Former Nestle Factory, Hayes
Ref: 1331/APP/2017/1883
Scheme Amendments

Following on from our recent discussions and to address officer comments, enclosed are amendments to the overall masterplan, the residential and the industrial scheme drawings that form the proposed redevelopment of the former Nestle factory site in Hayes.

**ILLUSTRATIVE ELEVATION UNIT 1**

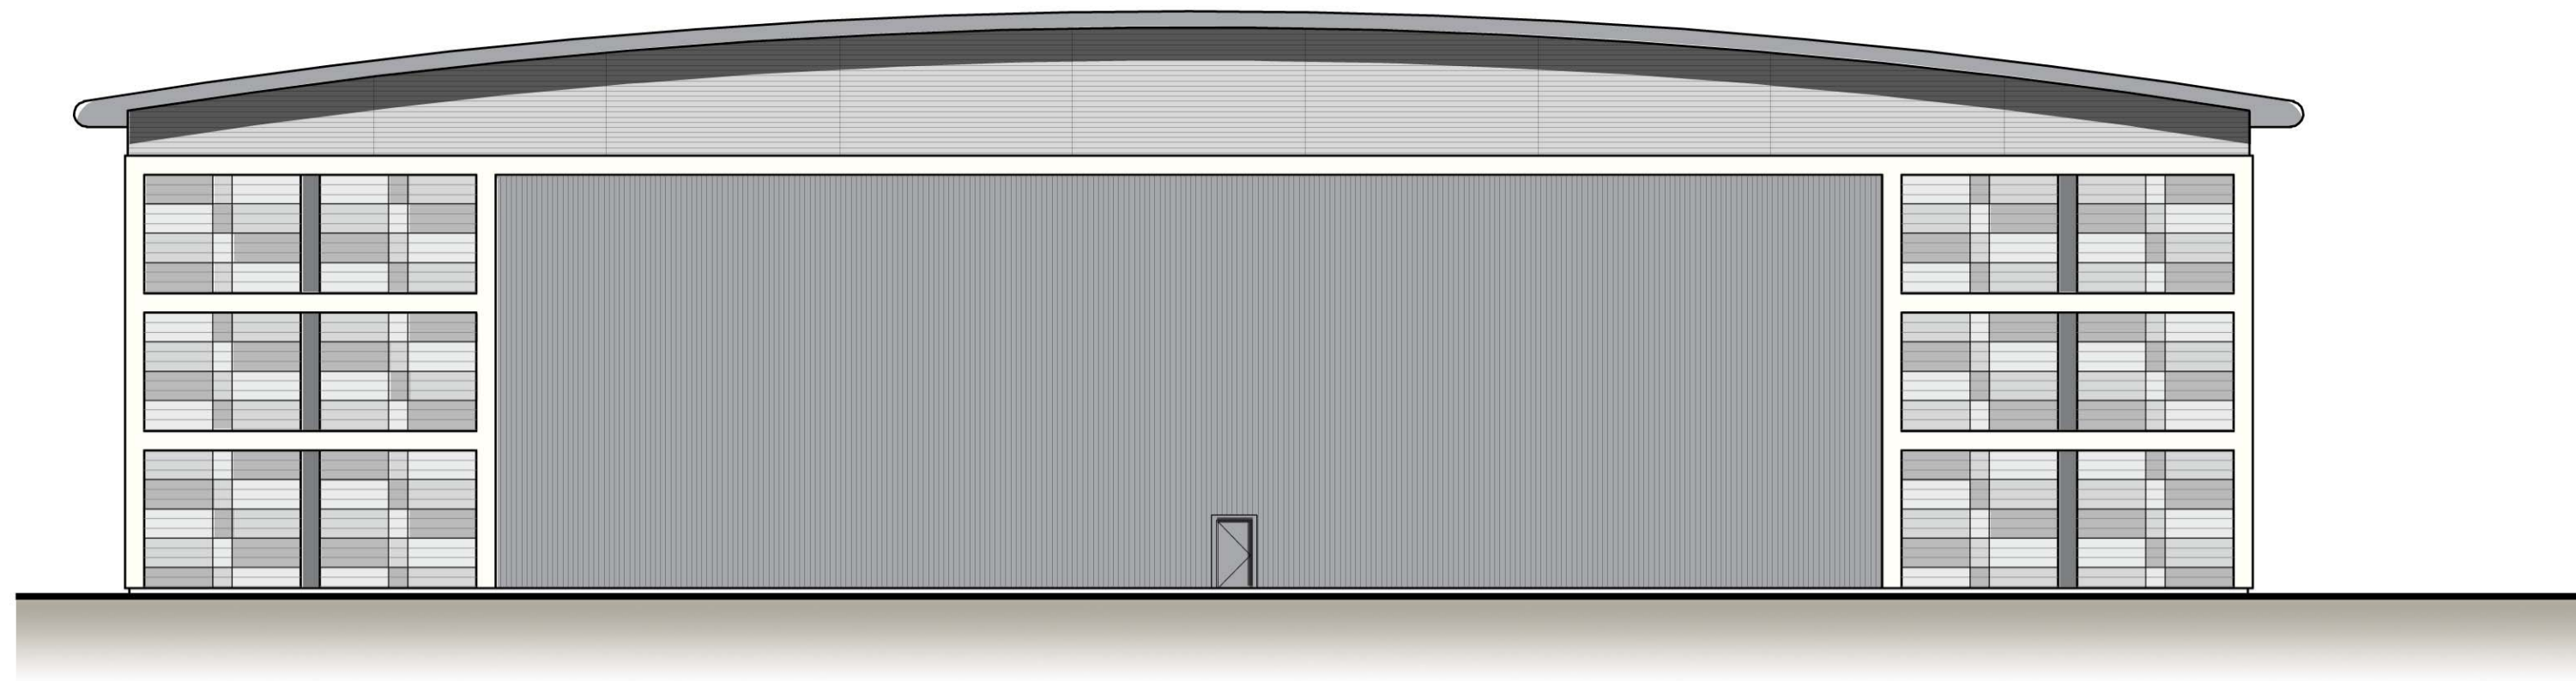
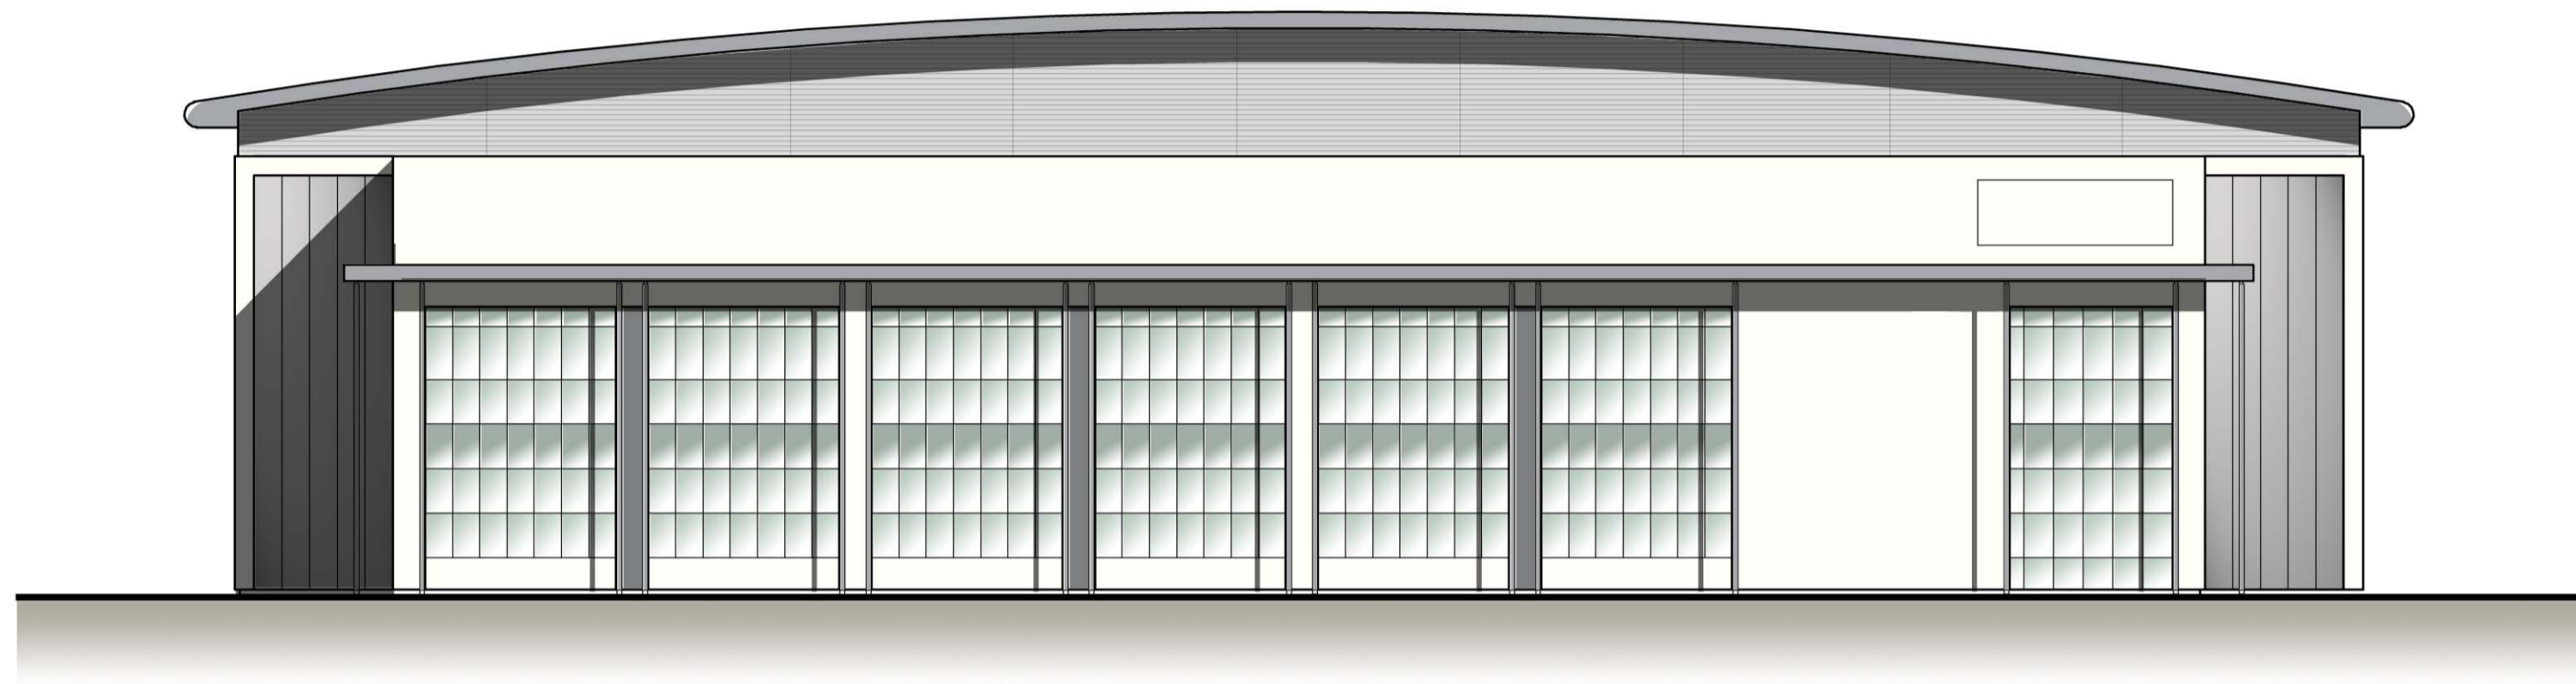
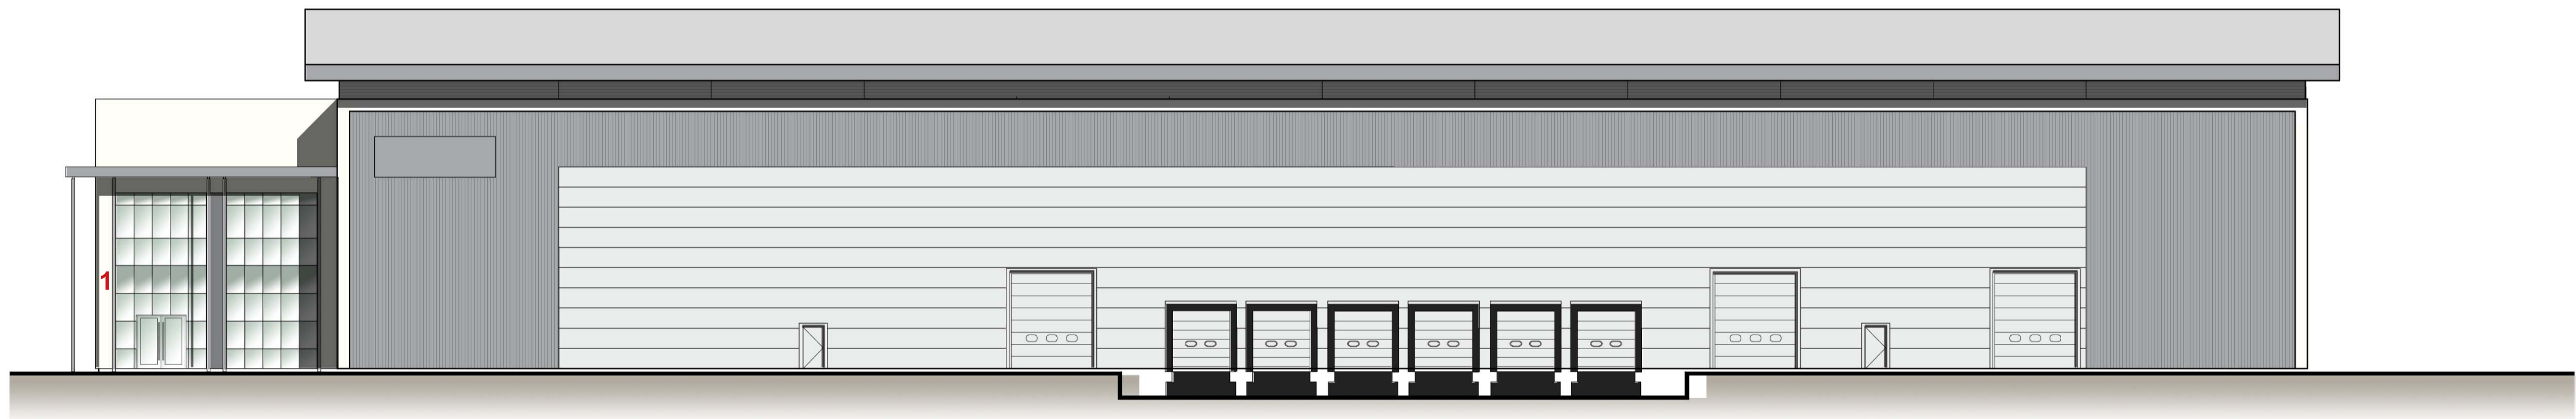
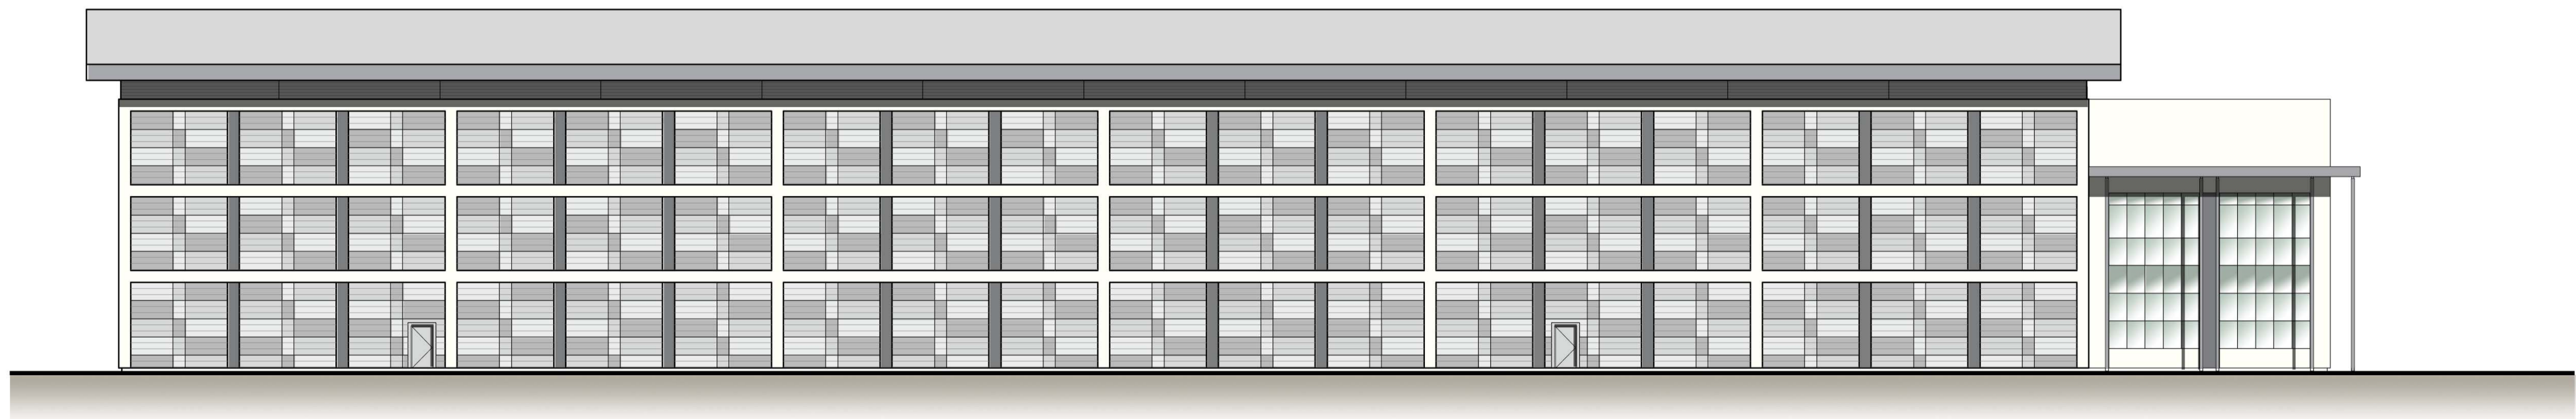
- MS200 & MS201 Elevations for Units 1, 2 & 3 – The pistachio colour has been introduced on as part of the curtain walling spandrel panels between ground and first floor and the elevations overlooking the service yards have been updated to reflect the white grid based on the design of the other elevations.
- MS202 Elevations for Unit 4 – The dark panels on the north elevation have been replaced by white ones.
- MS210, MS211 & MS212 Roof Plans for Units 1, 2, 3 & 4 – Show the indicative location of roof lights and the position of PV panels.
- MS102 & MS207 Data Centre Option for Unit 1 – Show the indicative size and position of the external plant, on site layout and elevation drawing, of a potential Data Centre in Unit 1.
